**Harnett County, North Carolina**  
**Telecommunications Site Review**  
**Collocation Application**

April 7, 2022

**PROVIDER/ID:** T-Mobile/5RA0965A  
**OWNER SITE NUMBER:** Utility Services Holly Springs  
**FACILITY OWNER:** Harnett Regional Water  
**ADDRESS:** 6908 Cokesbury Road, Duncan, NC, 27540  
**COORDINATES:** 35.564379 N; -78.870929 W  
**COUNTY NUMBER:** LUP#2202-0002

SHEET TITLE:	GENERATOR DETAILS
--------------	-------------------

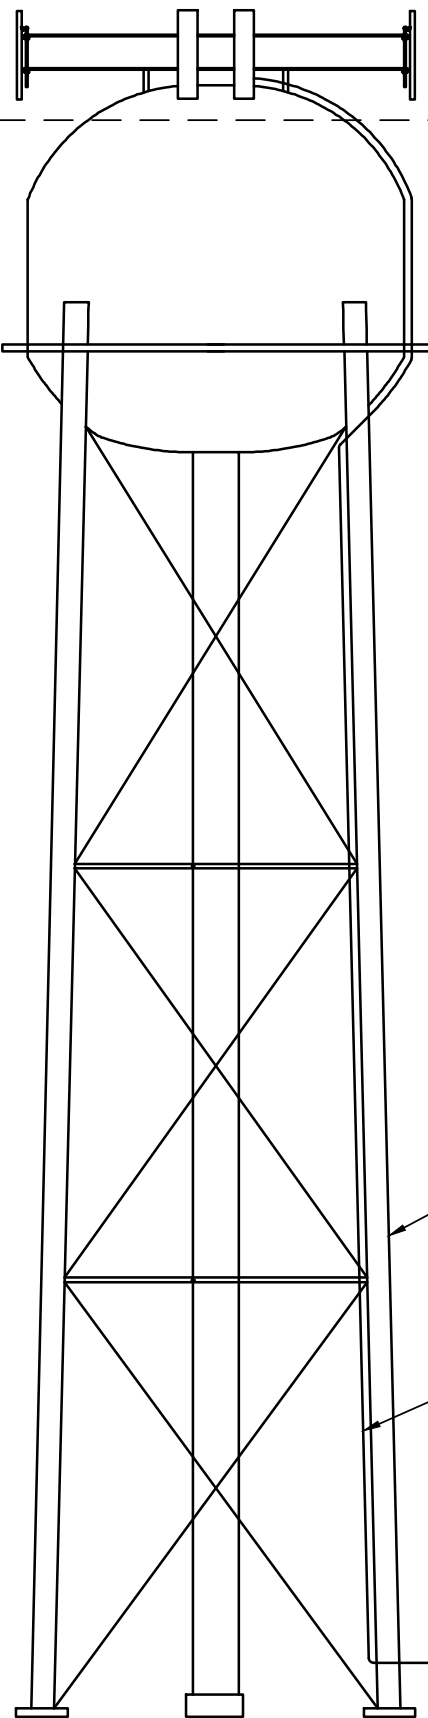
The generator must be installed in accordance with all relevant building, electrical and fire codes, and the Applicant must observe the maximum acoustic noise level as well as the allowable testing hours as per the County ordinance.

SHEET TITLE:  
**STRUCTURE ELEVATION & ANTENNA PLAN**

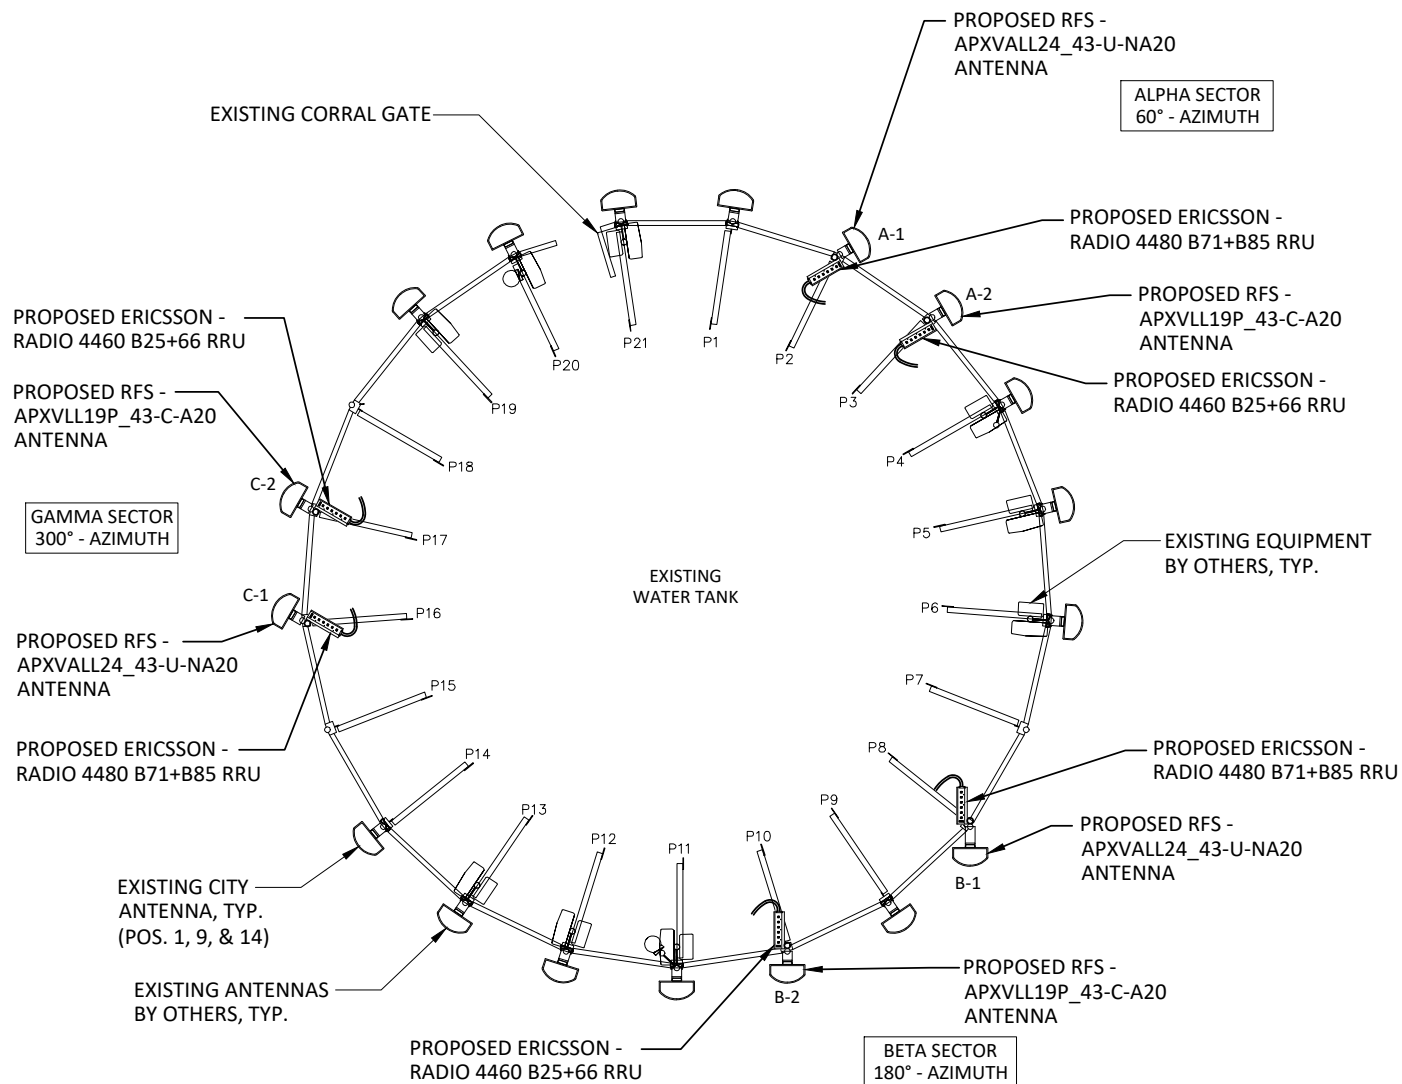
It is noted on the construction drawings that T-Mobile will paint the corral and all antenna mounts, mounting brackets and hardware to match the tower. Cables will be installed in the inside face of the tank leg and cables over the bowl of the tank must have four (4) foot separation from the tank logo and be shrouded with shrouding painted to match the tank.
